Re: Camp Agape

This department has reviewed the plan you submitted for the Camp Agape swimming pool to be constructed at 1369 Tyler Dewar Ln, Fuquay Varina. This plan review was conducted in accordance with the current North Carolina Rules Governing Public Swimming Pools (15A NCAC 18A .2500).

Further information is needed regarding the following items for review to continue:

1
P2 PARTIAL FLOOR PLAN - DOMESTIC WATER
1/4" = 1' - 0"

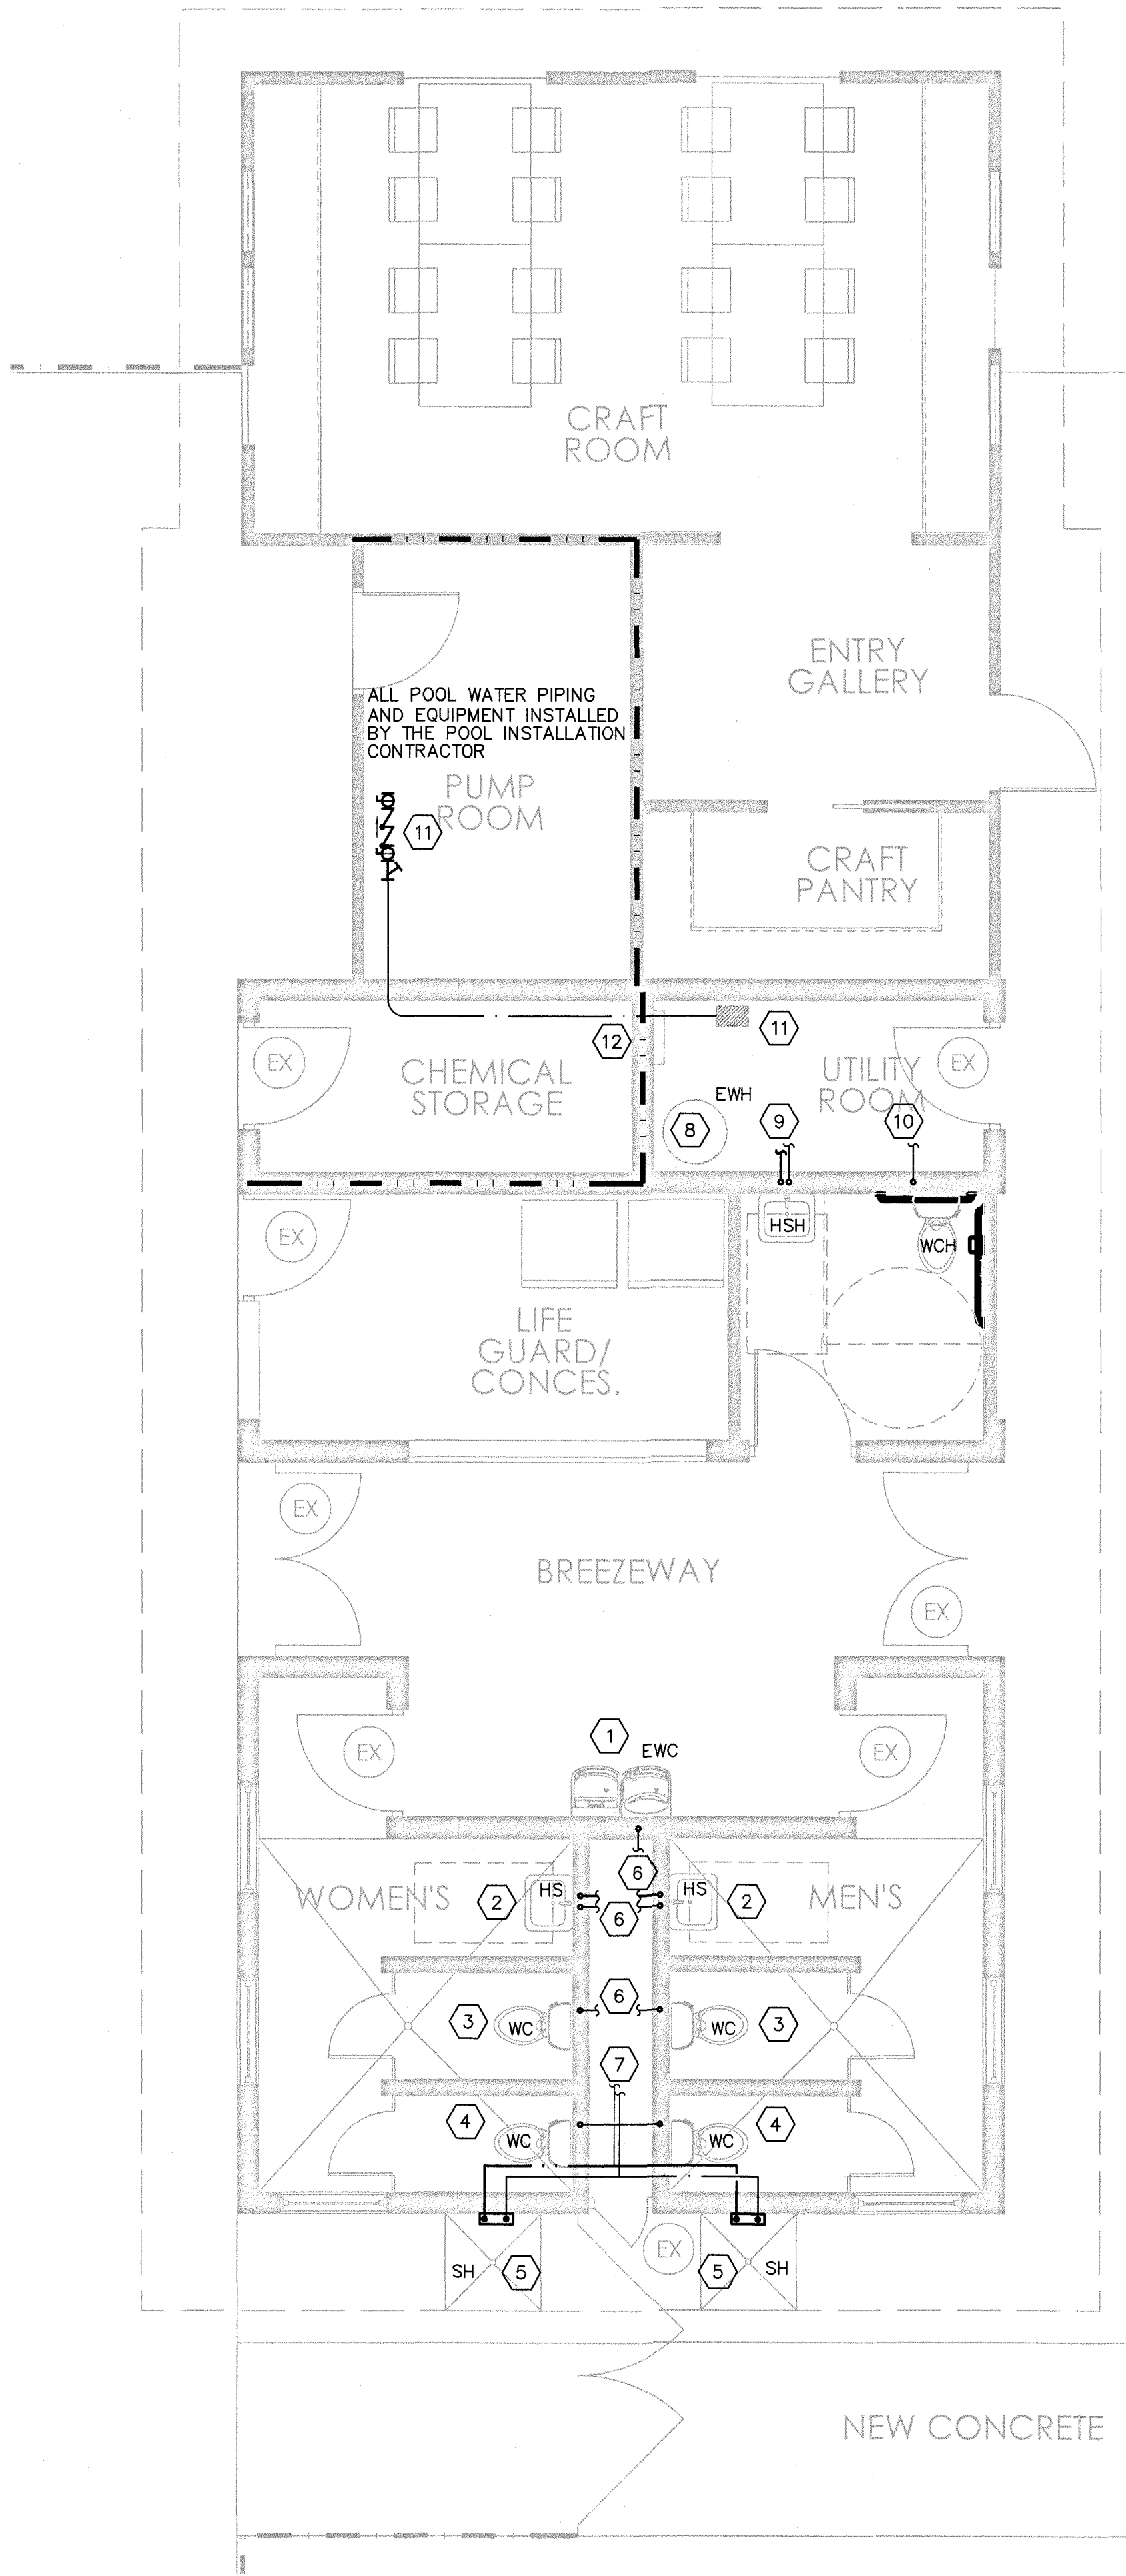
- Hose bibb placement is not clear. There appears to be no provision for a hose bibb on the plumbing supply plan. One hose bibb is referenced on the pool plans but is not included in any plumbing schematics. No hose bibs are shown on the amenity building plans. Clarify placement of hose bibbs.

HYDROSTATIC RELIEF VALVE, TYP. (AT LOCATION OF HIGH GROUND WATER)

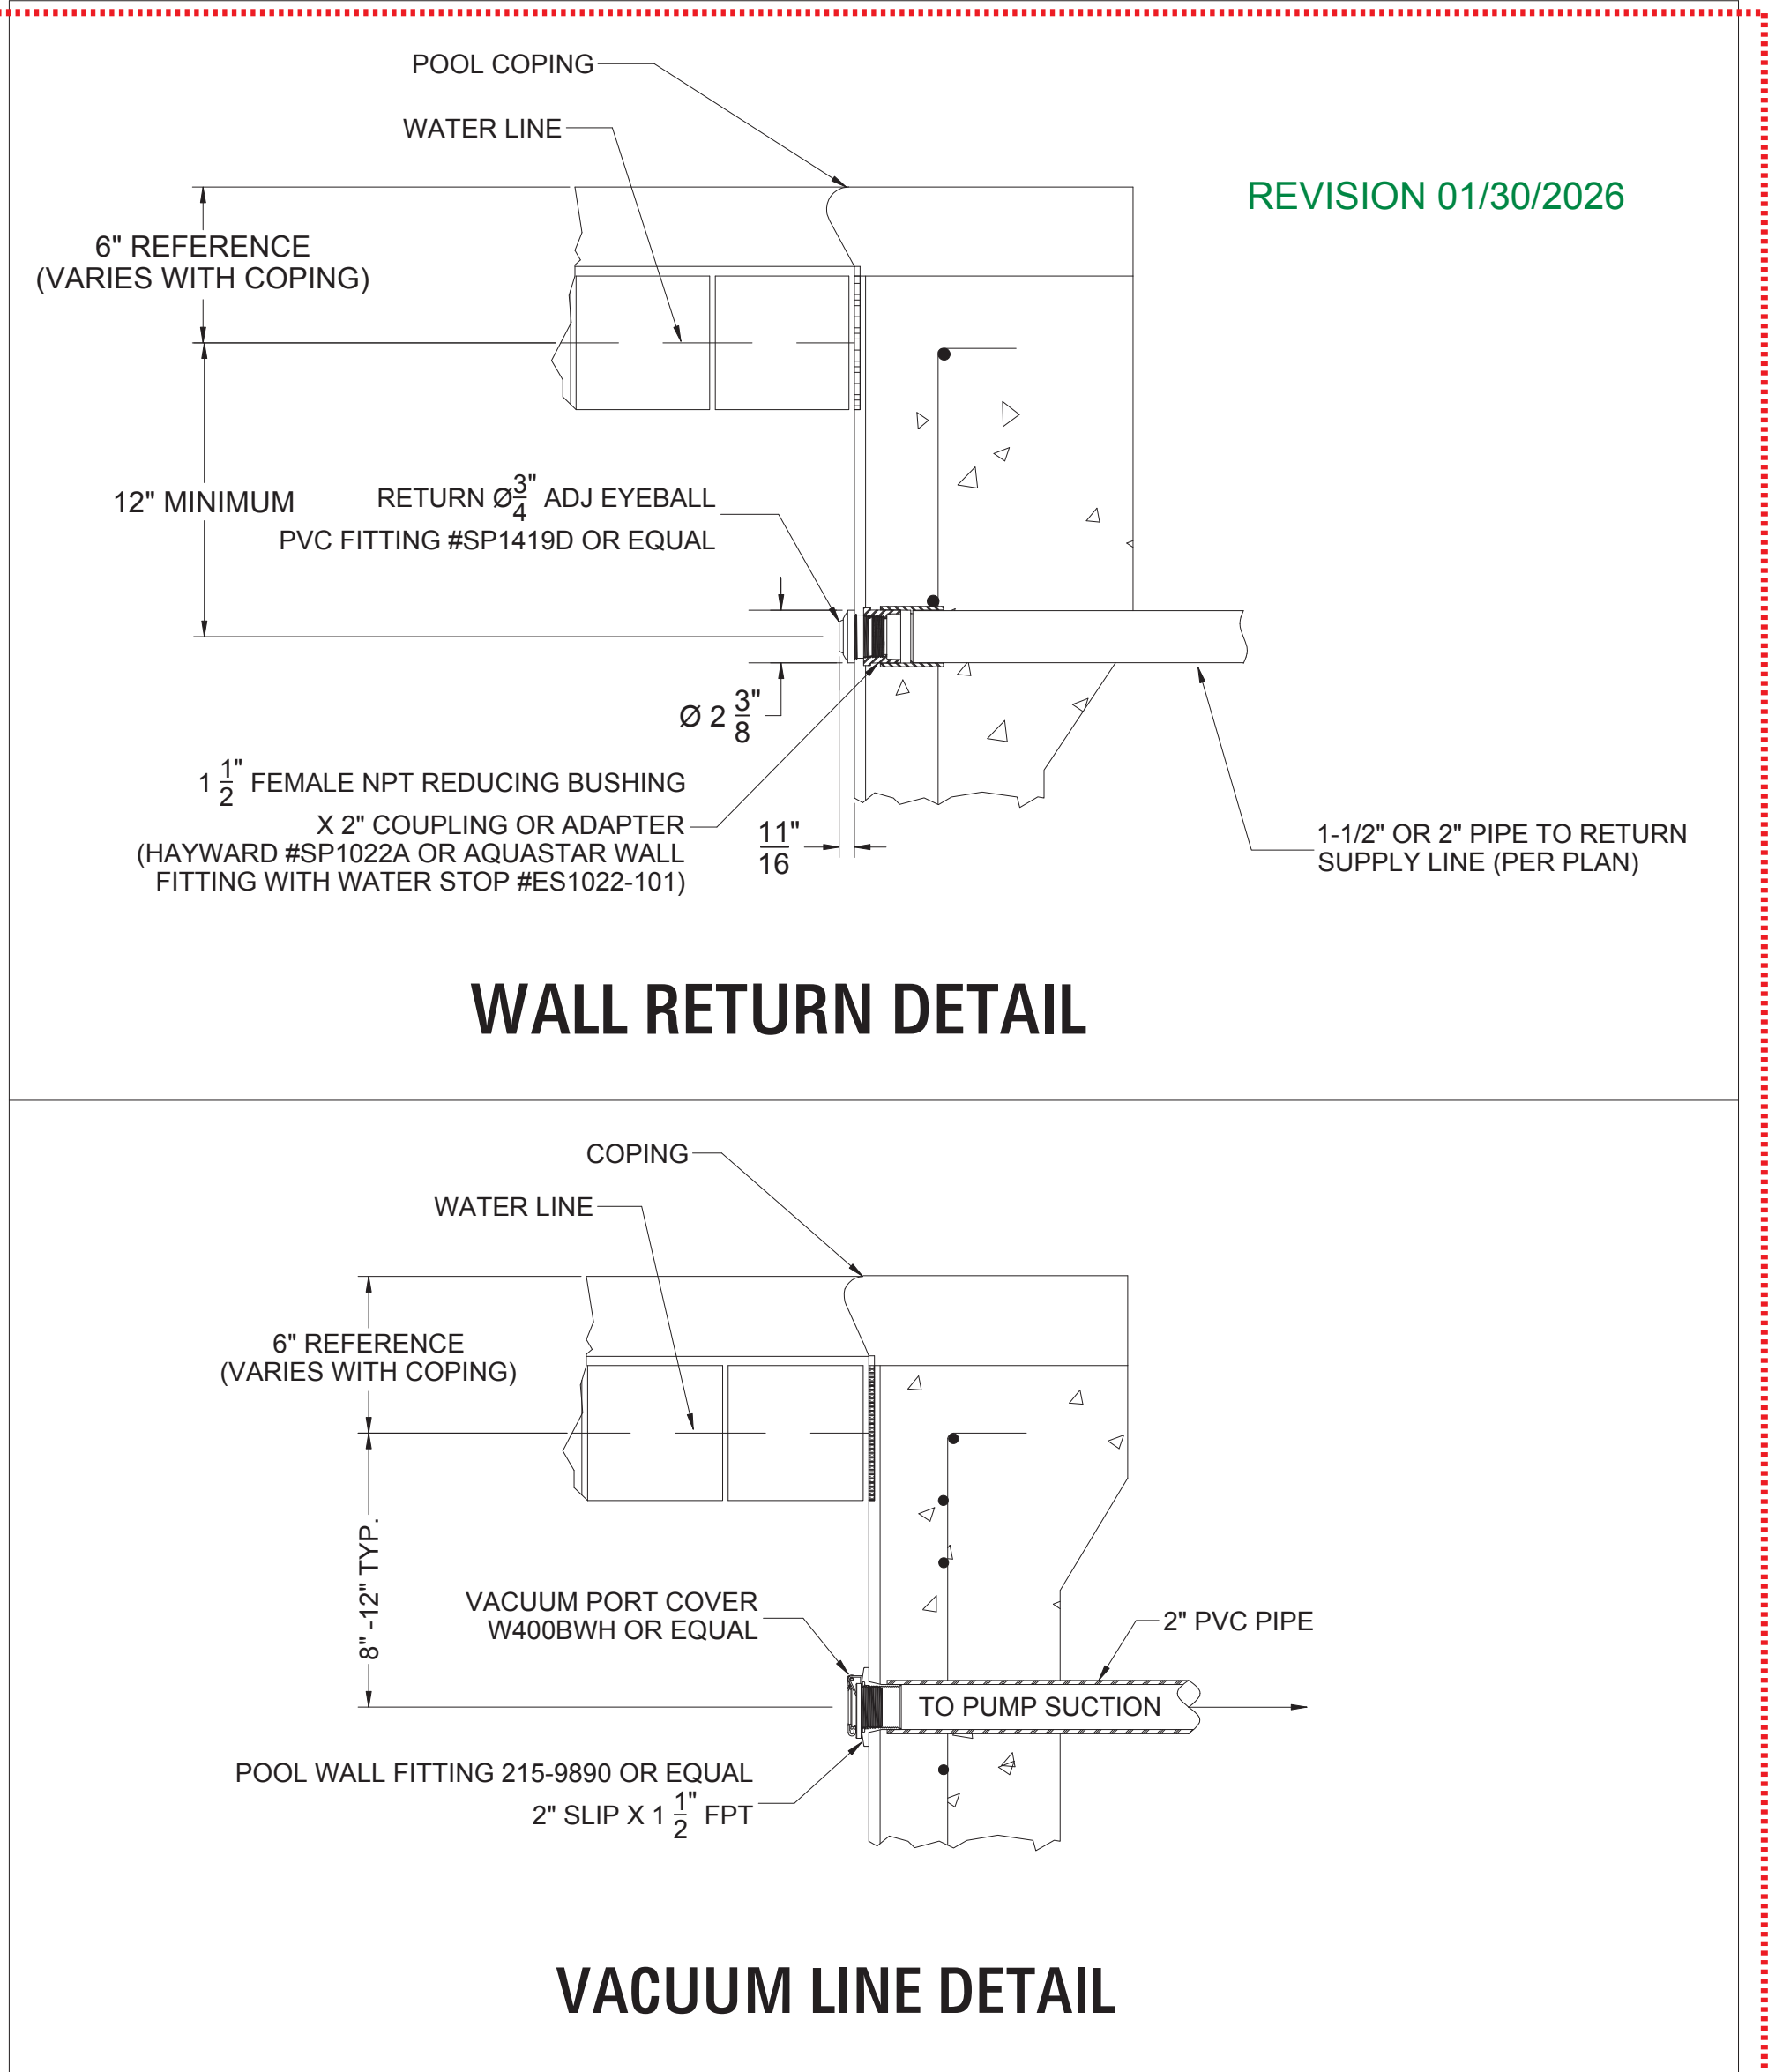
- Provide locations and specifications on all deck drains if provided
- Provide a make/model or specification for a hydrostatic relief valve assembly
- Specification sheets were provided for quartz plaster but a specific color was not indicated.

VACUUM LINE DETAIL

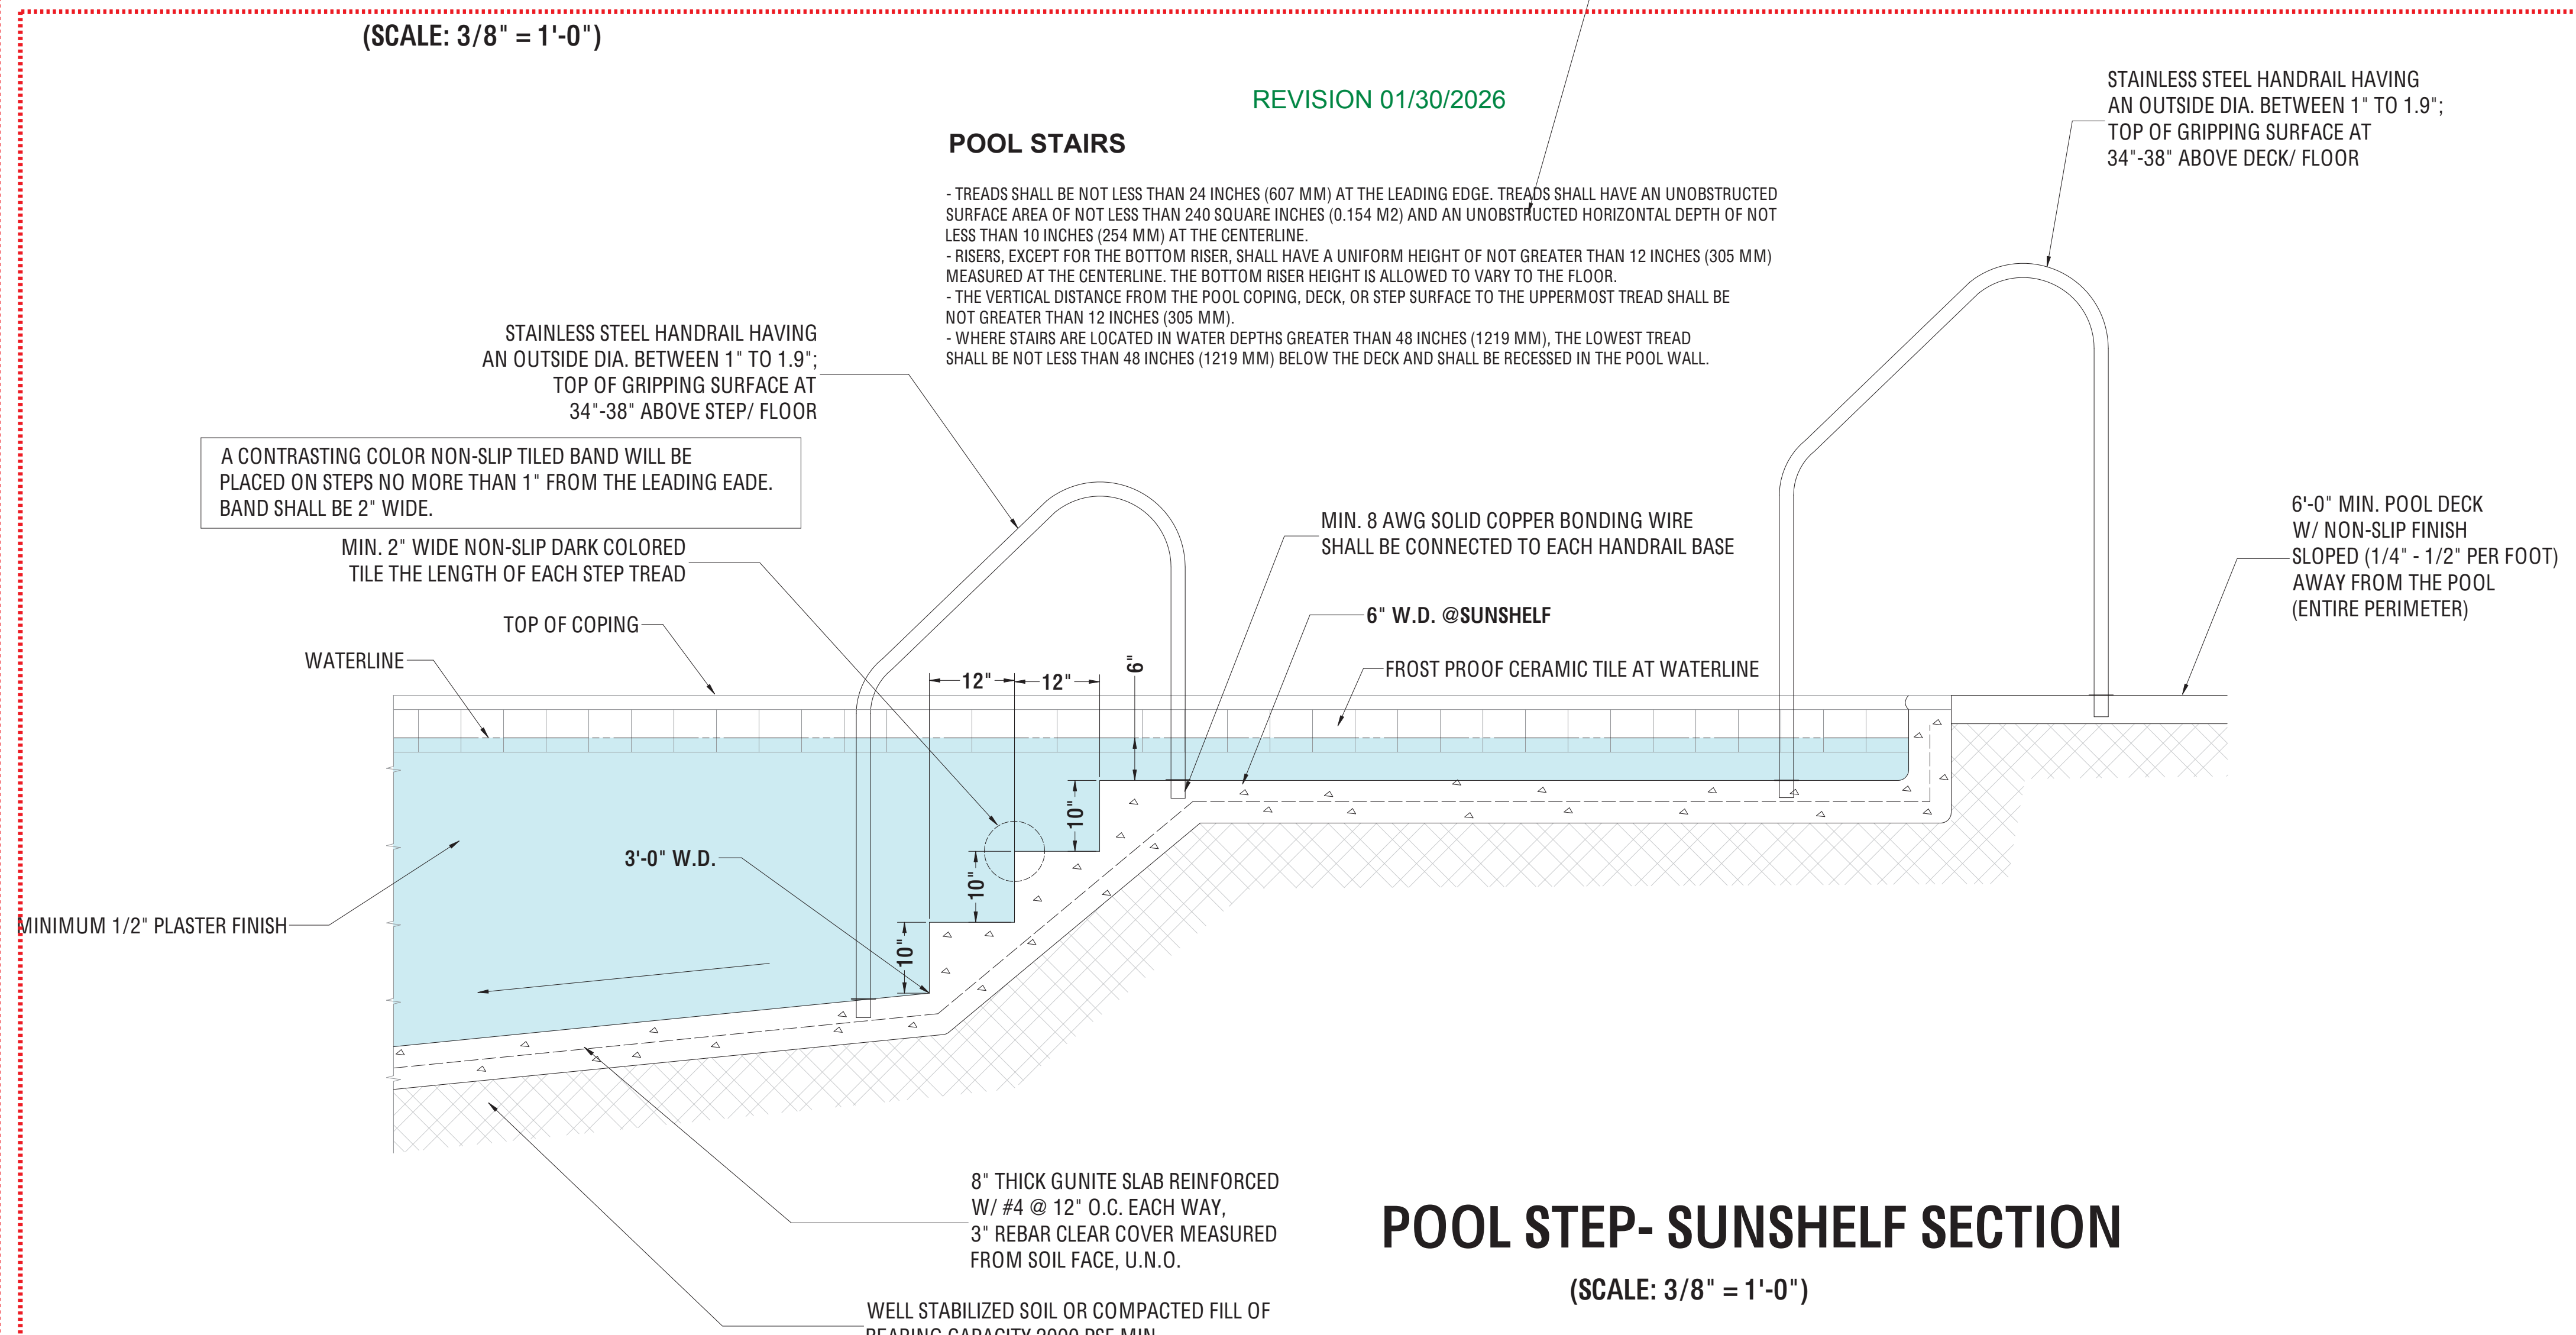
- Elevation/detail blowups of steps, bench and vacuum line installation either not provided or not complete with needed details (such as specific location and material used for contrasting color bands on steps and bench, depth of bench installation, depth of vacuum line installation specific rise and run of each step etc).
